From: Farhad Khatibi
Sent: 30 October 2023 11:43
To: Planning ContactCentre
Cc: JohnM Hinchliffe
Subject: RE: Attached letter from Kirklees Council regarding application number 2023/91870 at location Rough Nook Farm, 112, Mill Moor Road, Meltham, Holmfirth, HD9 5LW

I would like to advise that conditions 4 (retaining walls) and 5 (drainage in highway) can not be discharged for the following reasons:

Title: Section 104 Drainage Layout and Schedules

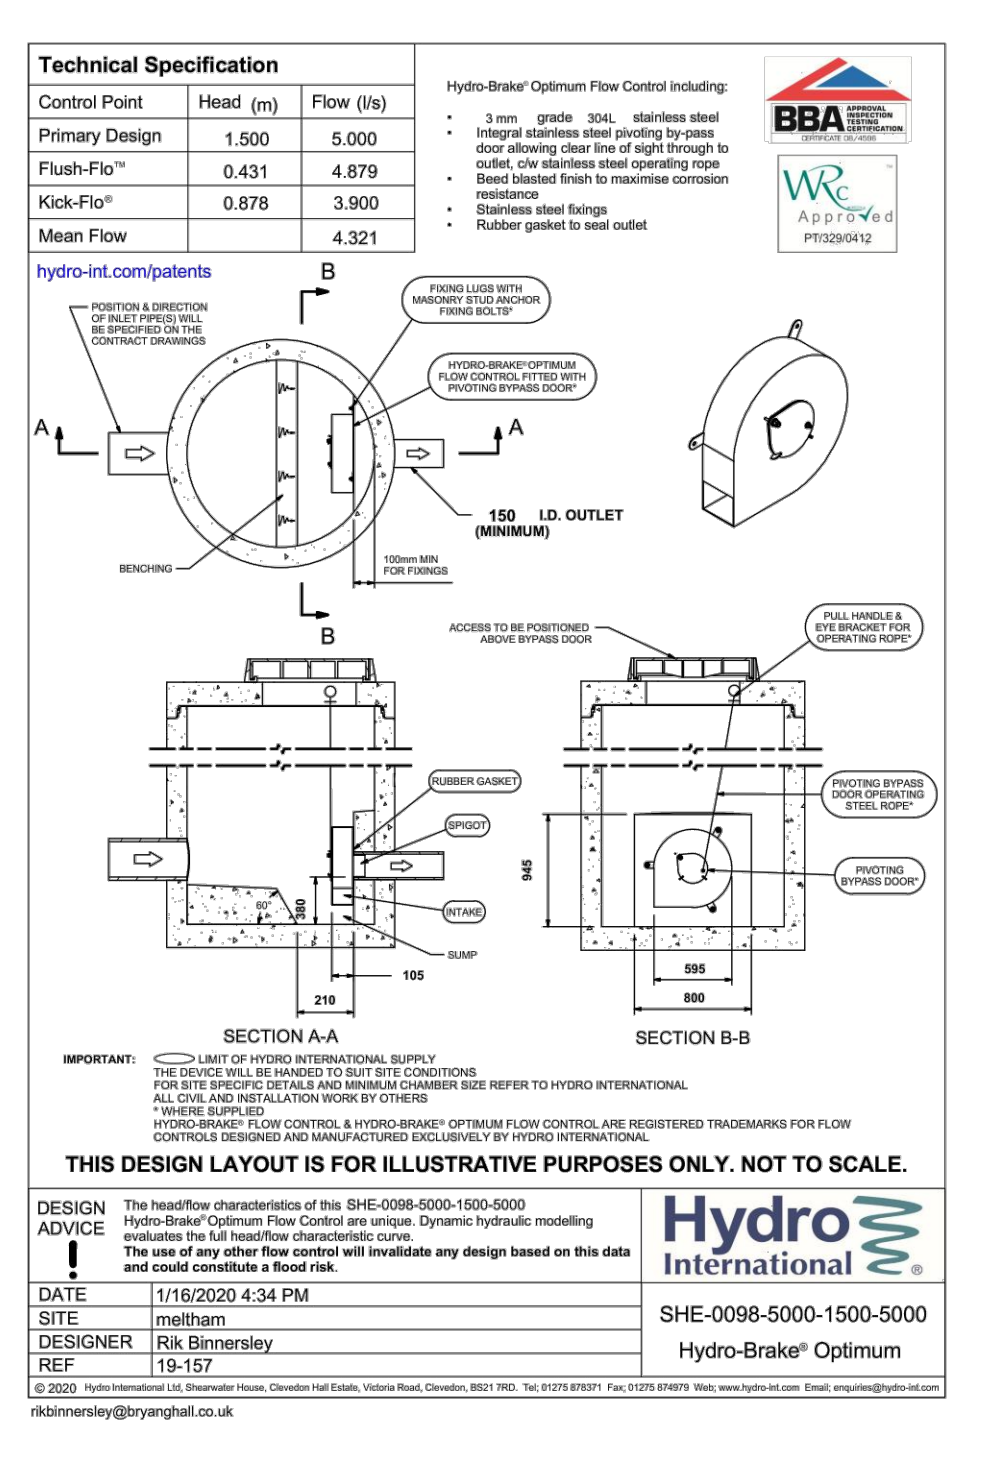
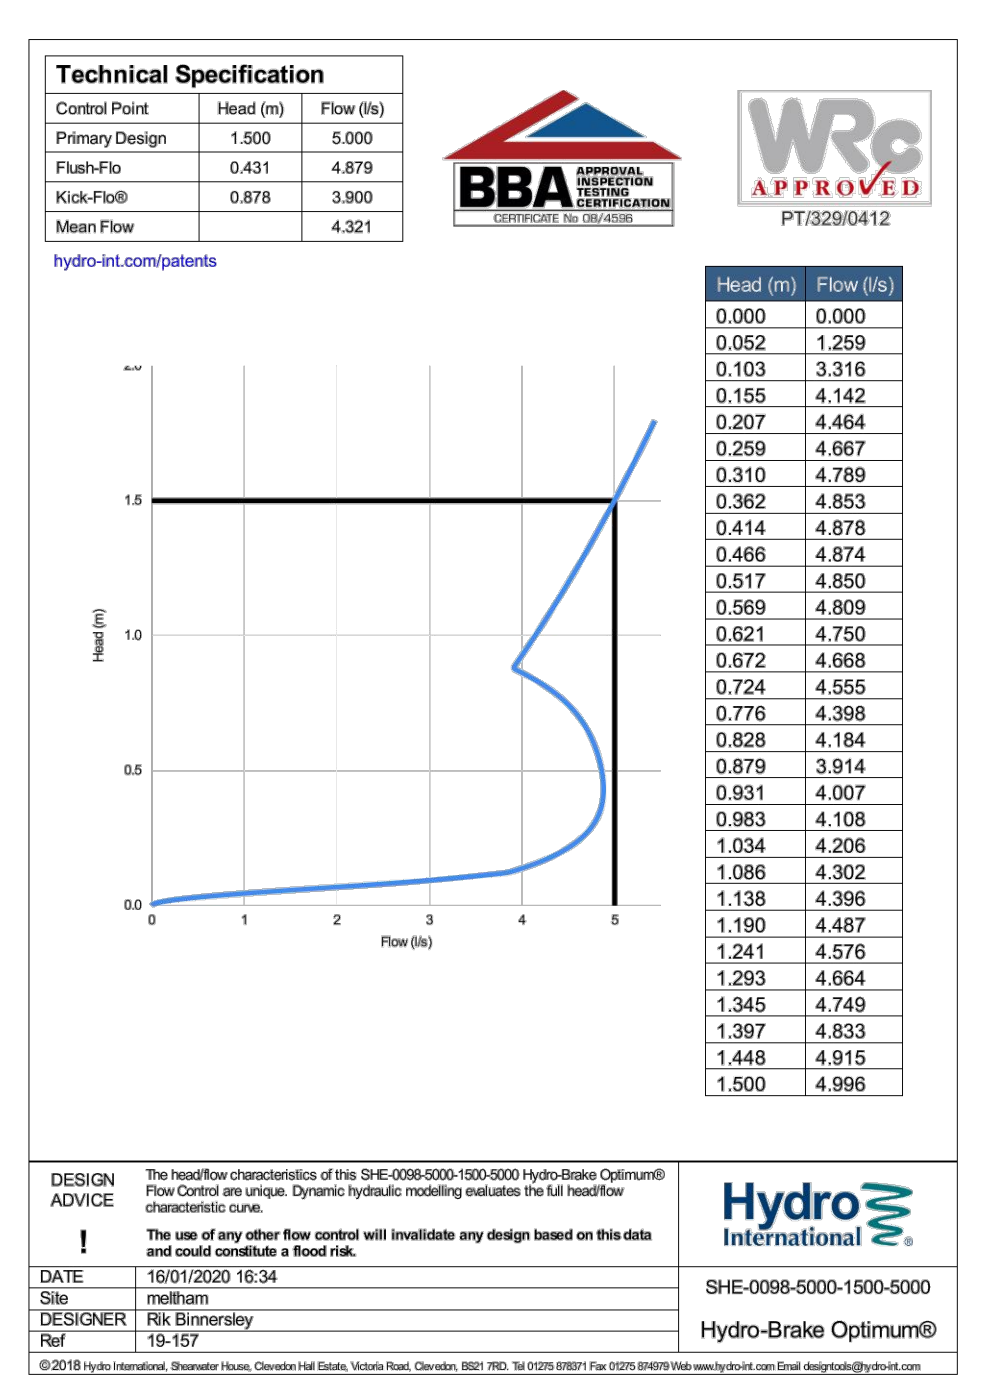
- 1) The discharge of condition 5 will be strictly subject to the compliance of the proposed surface water attenuation system with our policy which does not permit the positioning of pipes/ culverts with ID/Span > 0.9m under the adopted highway. See <https://www.kirklees.gov.uk/beta/regeneration-and-development/pdf/highways-structural-procedures.pdf> for further details.
- 2) The amendment of all relevant drainage drawings including notes to comply with the current the Sewer Sector Guidance for adoption ("the Code") with particular reference to oversize PCC manholes and their cover slabs with ID > 0.9m.
